TransGrid Reference Number: 2021-144

Proposal: Notice of Exhibition – Oxley Solar Farm (SSD-10346)

Please find TransGrid response to **2021-144 Notice of Exhibition – Oxley Solar Farm (SSD-10346)**

APPENDIX B PROPOSAL PLANS

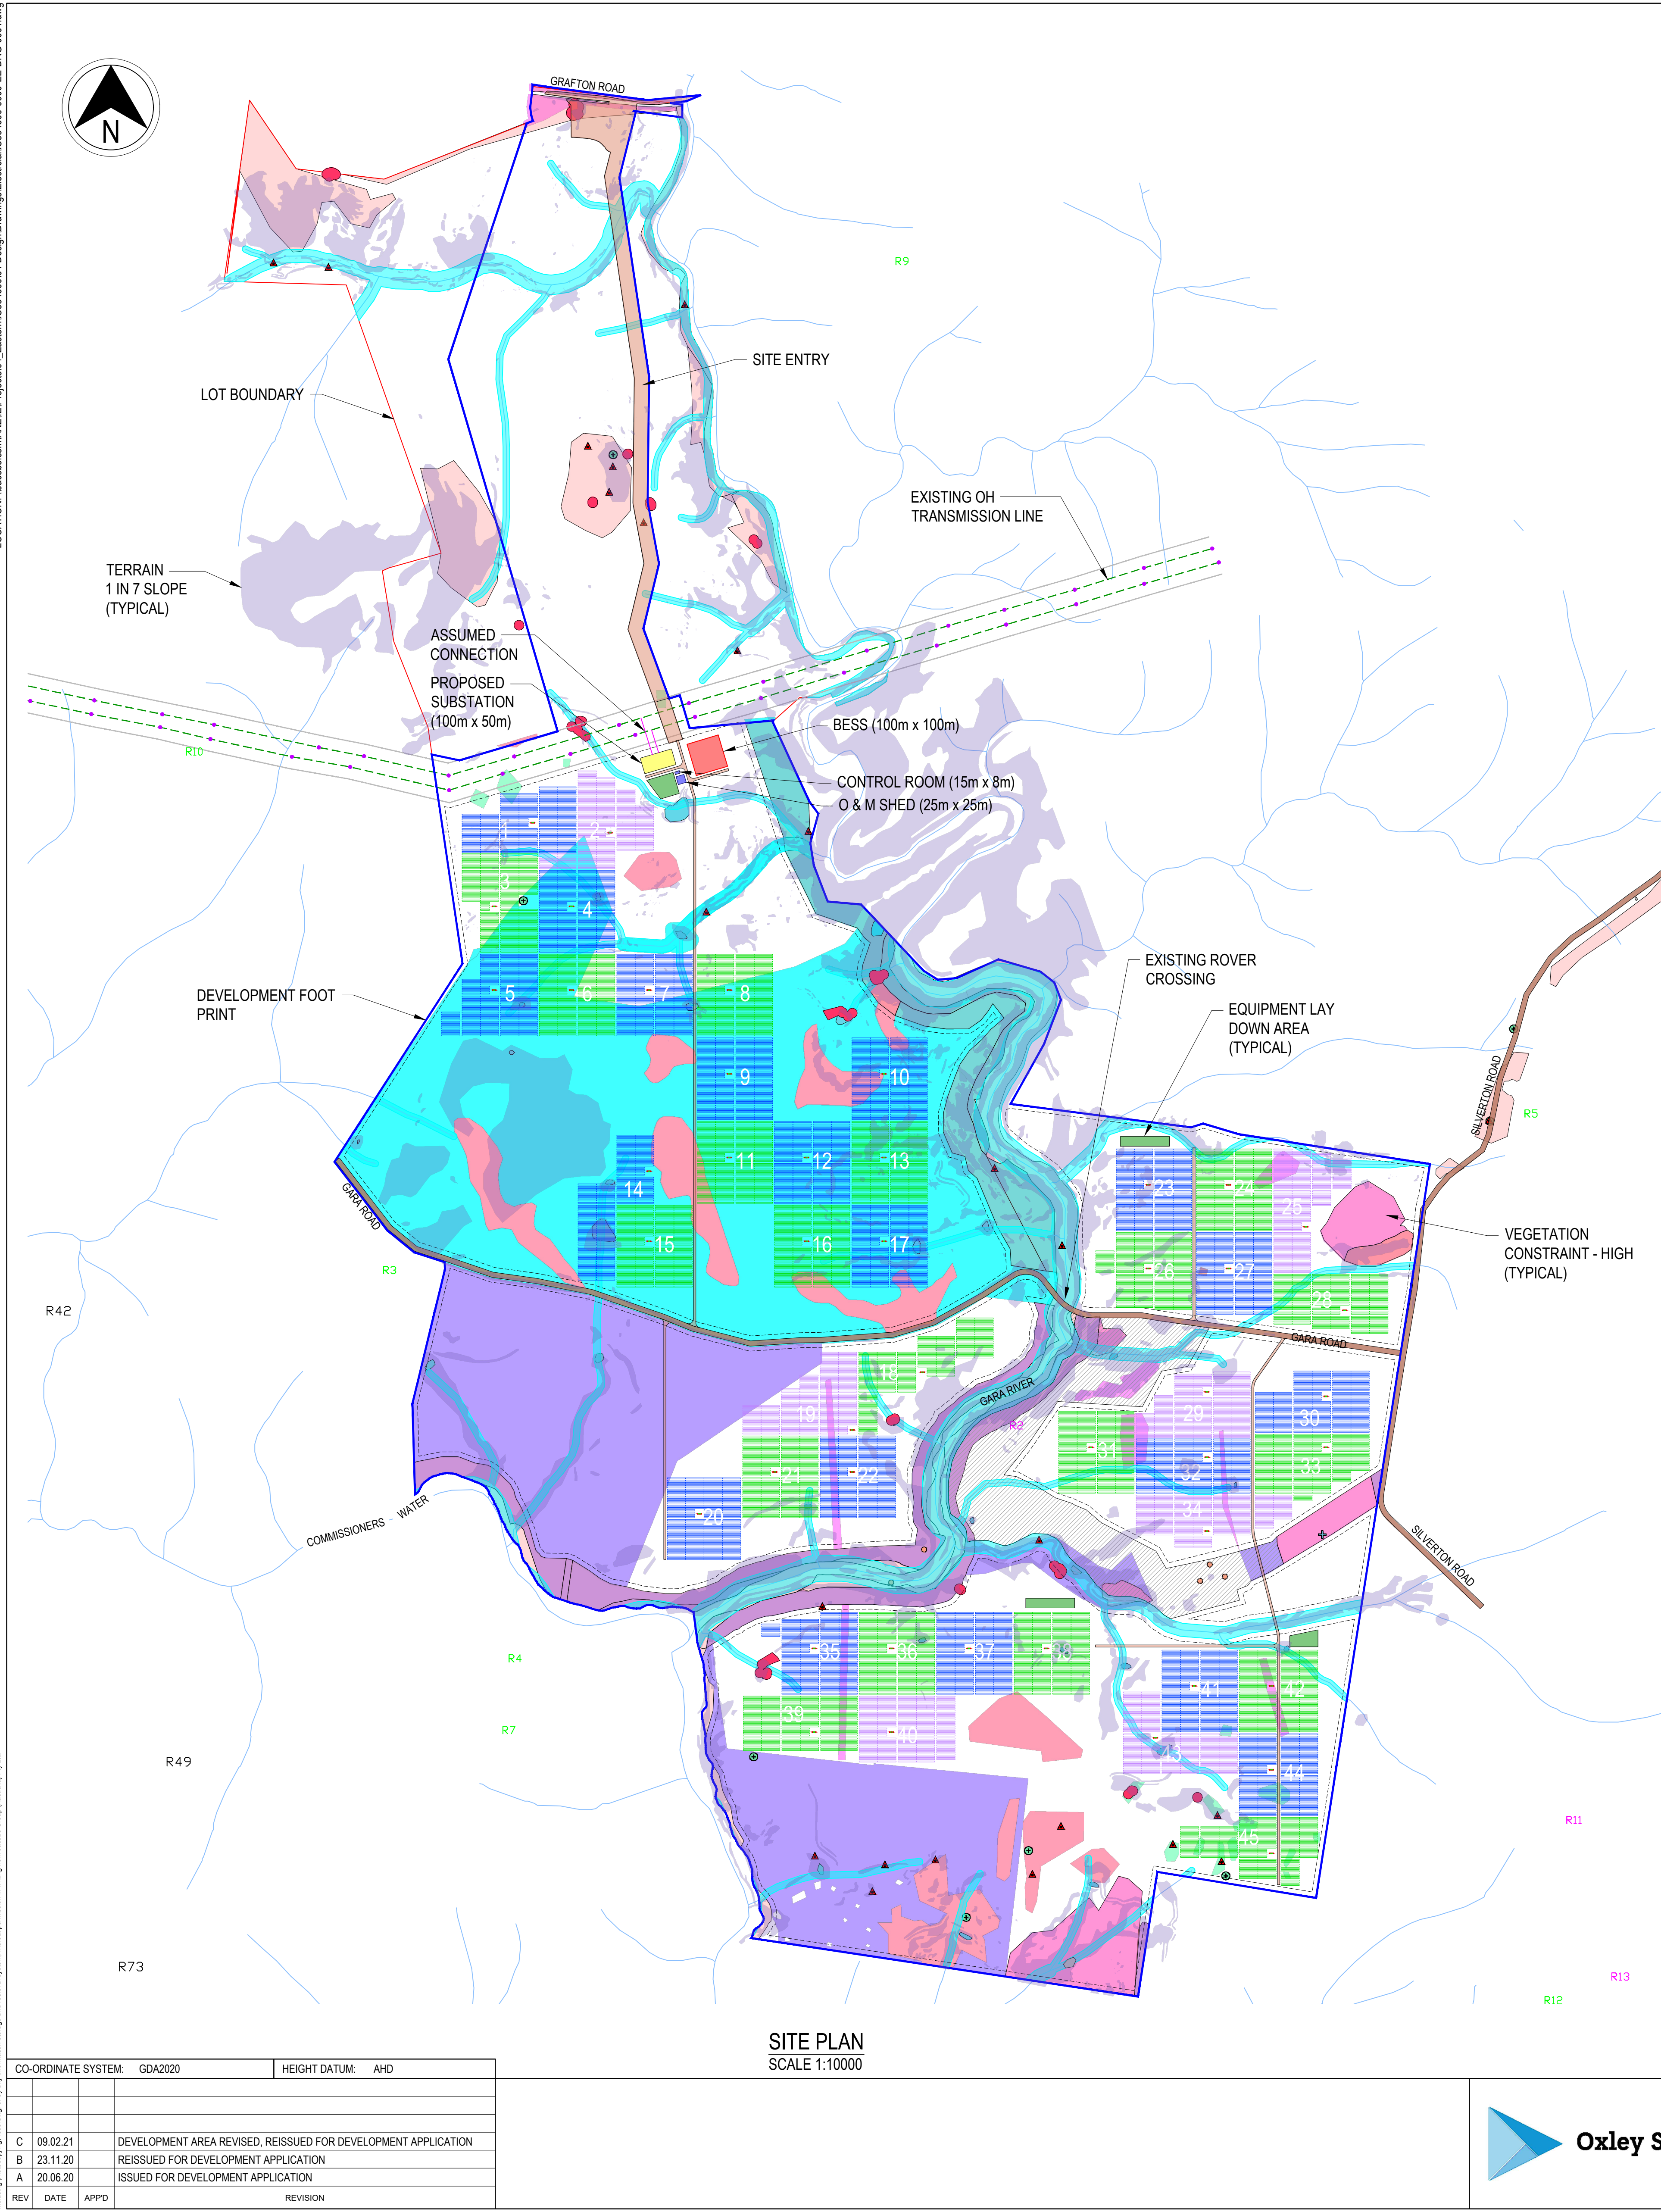
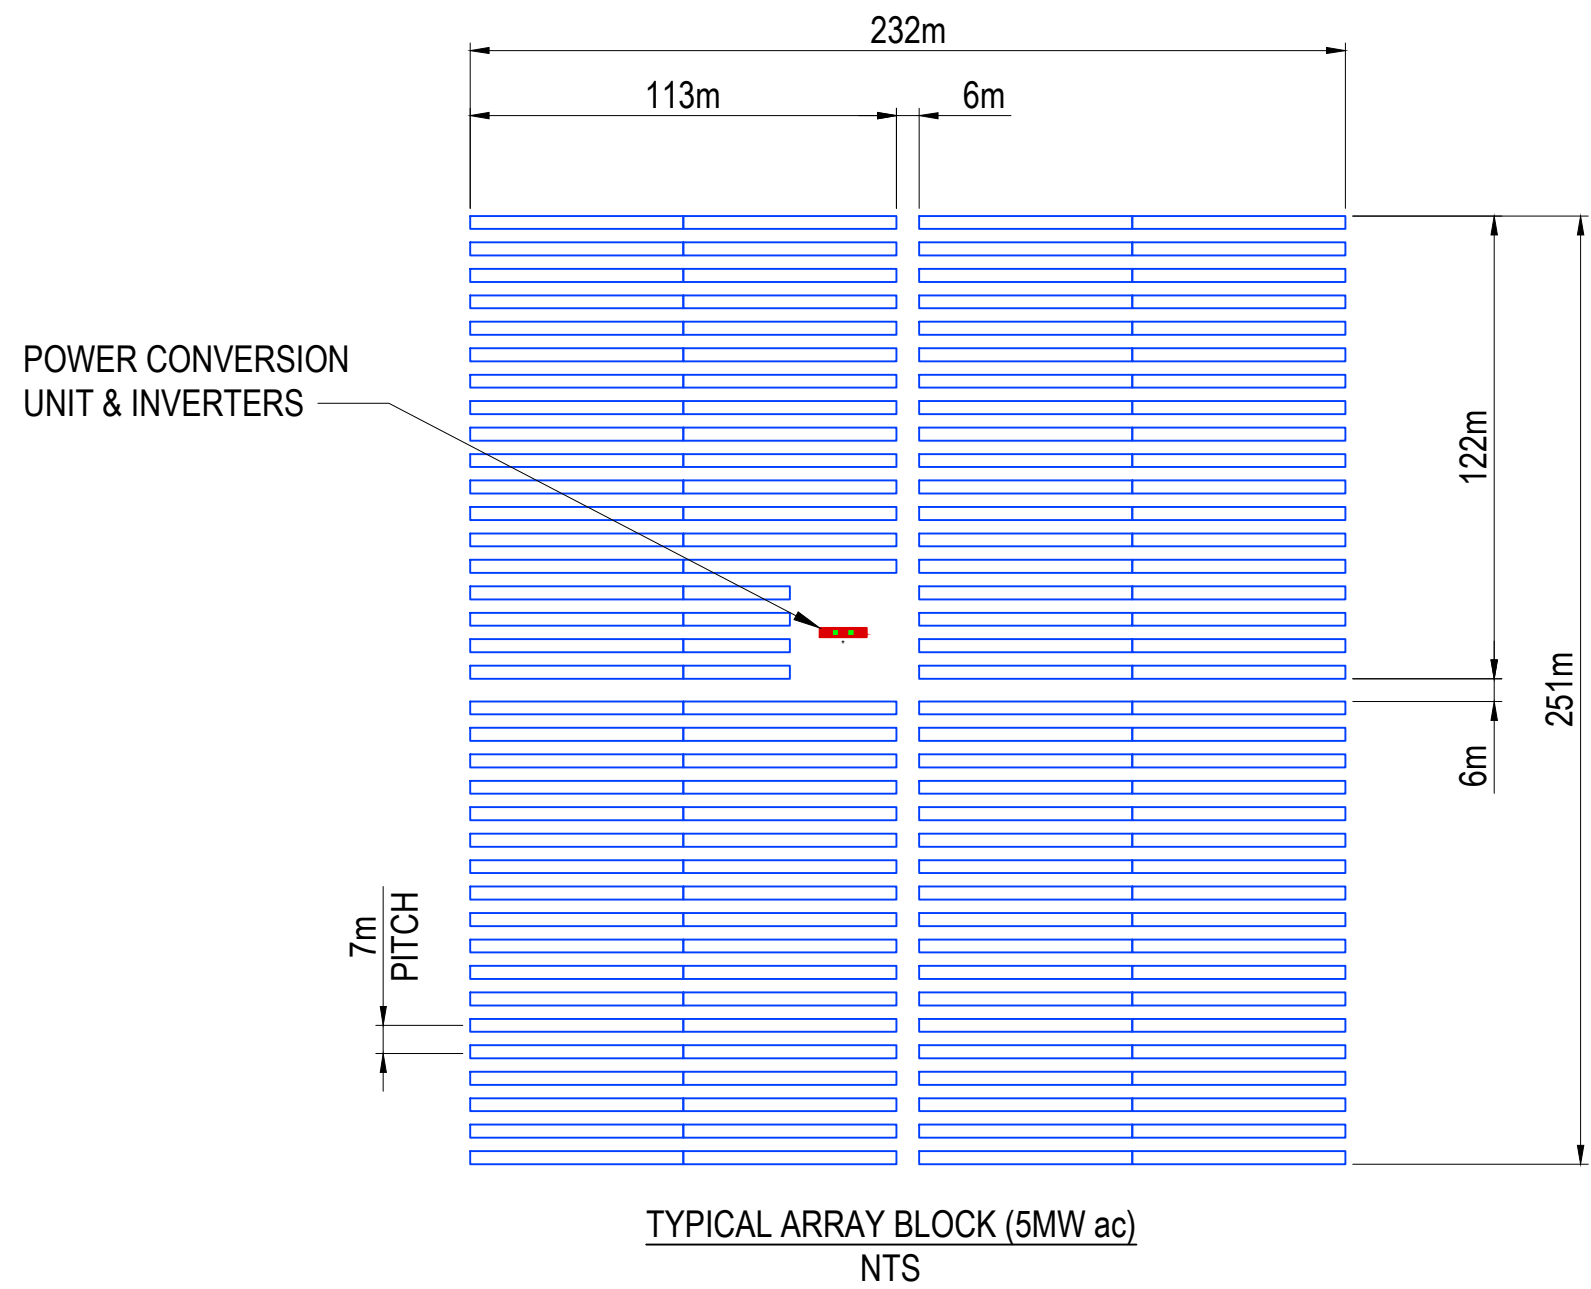
- Provide shape files of the project so we are able to confirm that TransGrid's easement is being avoided and appropriate set backs are in place;
- Liaise with TransGrid when finalising the design of proposed 132kV Substation, to ensure the substation is constructed as per TransGrid's standards;
- Shape files of proposed connection between the substation and TransGrid's transmission line;
- The proponent is to continue liaising with TransGrid to satisfy clause 5.3.4 of the National Electricity Rules and determine the terms of ownership, maintenance and operation of new 132kV substation.

- The proposal does not appear to have allocated adequate land for the substation site. The proposed site is only 50m x 100m.
- The minimum allotment should consist of the footprint of the substation defined by the security palisade fence, any ancillary buildings and 20 metres of freehold buffer land surrounding all buildings and the substation.
- The proponent should reappraise the proposed footprint for the substation site and scale up the size of the substation site as required.
